Outline application with some matters reserved for the conversion of existing dwelling into 5 self contained flats with front, rear, side & dormer extensions (resubmission following AW/71/17/OUT).

14 Princess Avenue Aldwick

Thank you for your internet representation made on 21st December 2017 which has been recorded as '**an objection**' with the comments as follows:

Proposed Flat Conversion. Site & Block Plan.

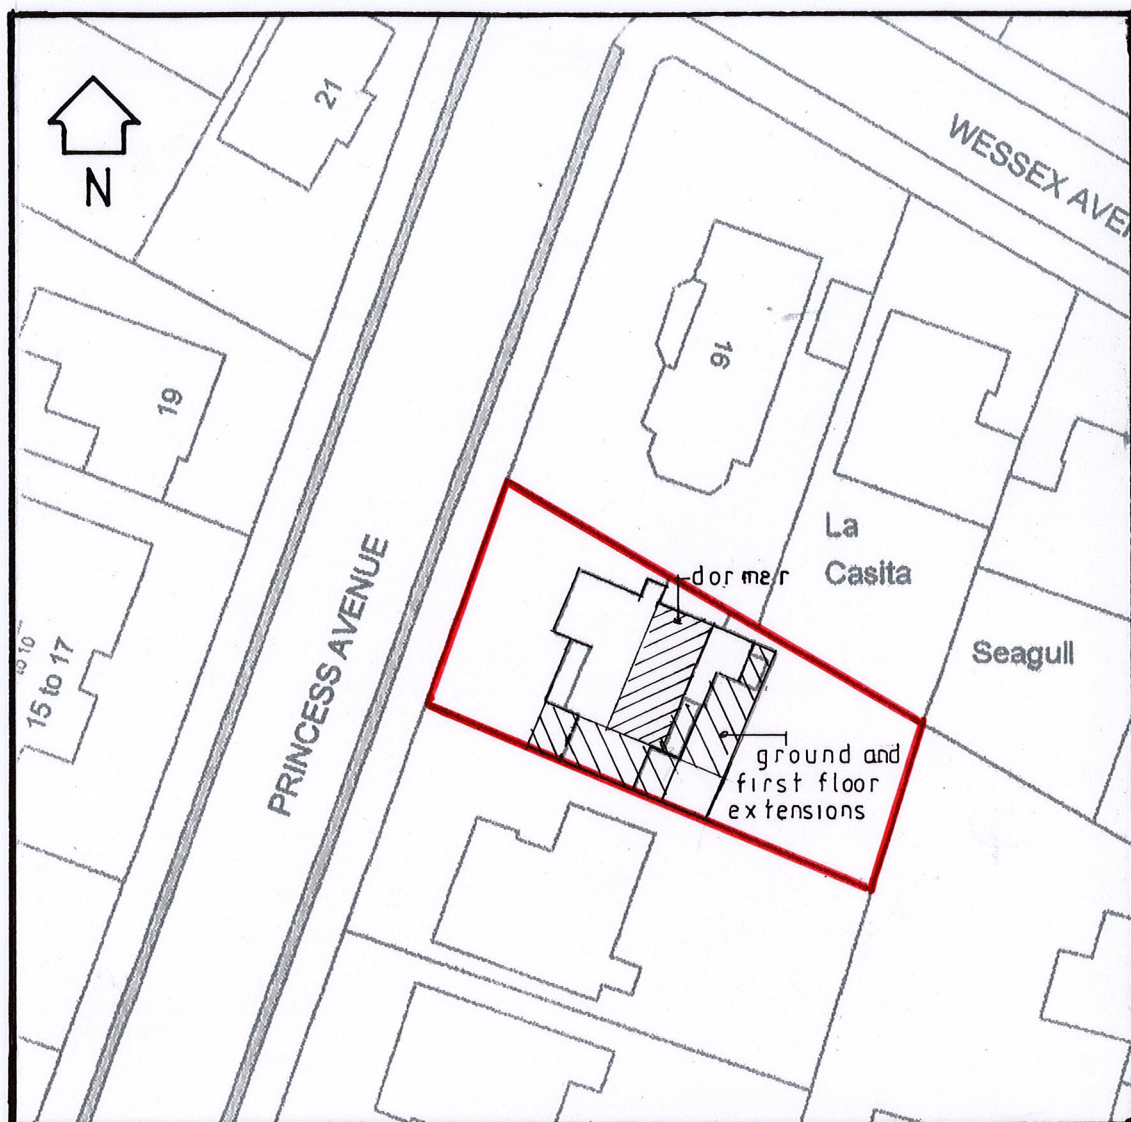
I'd like to draw to attention the part of the planning permission which is incredibly vexatious. Whilst looking at the planning permission it is clear that the residential bins and cycle shack will be placed next to my rear garden wall. Firstly in regards to the bins they will be in use by 5 flats, it is obvious to say that the smell from a bin is repulsive and even

**Proposed Flat Conversion.
Cycle & Bin Store.**

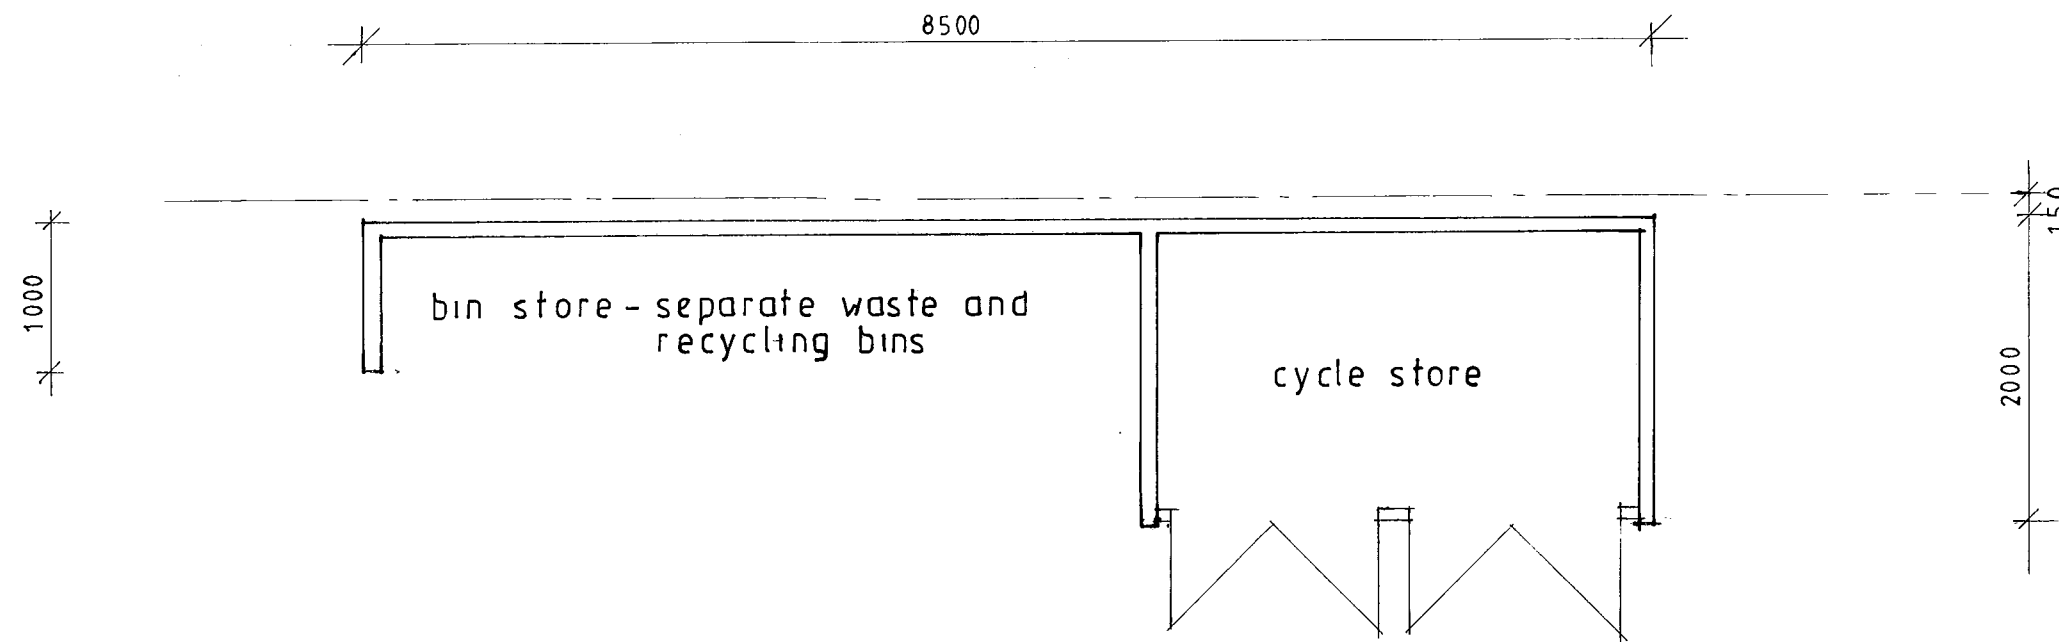
more so when it is hot. My garden and back of my house is hit by the prevailing south westerly winds, which by direction of the bins, would transport the foul smell to my residents. This could greatly affect my quality of life as I wouldn't be able to have friends and family's round in my garden for fear that we may smell the bins and ruin our social occasions. In regards to the cycle shack the contents of this could possibly bring the idea of thieves to the area, which in turn could align themselves to my property. This would then make me feel unsafe in my own home and live in fear that I could be the victim of Theft or Burglary.
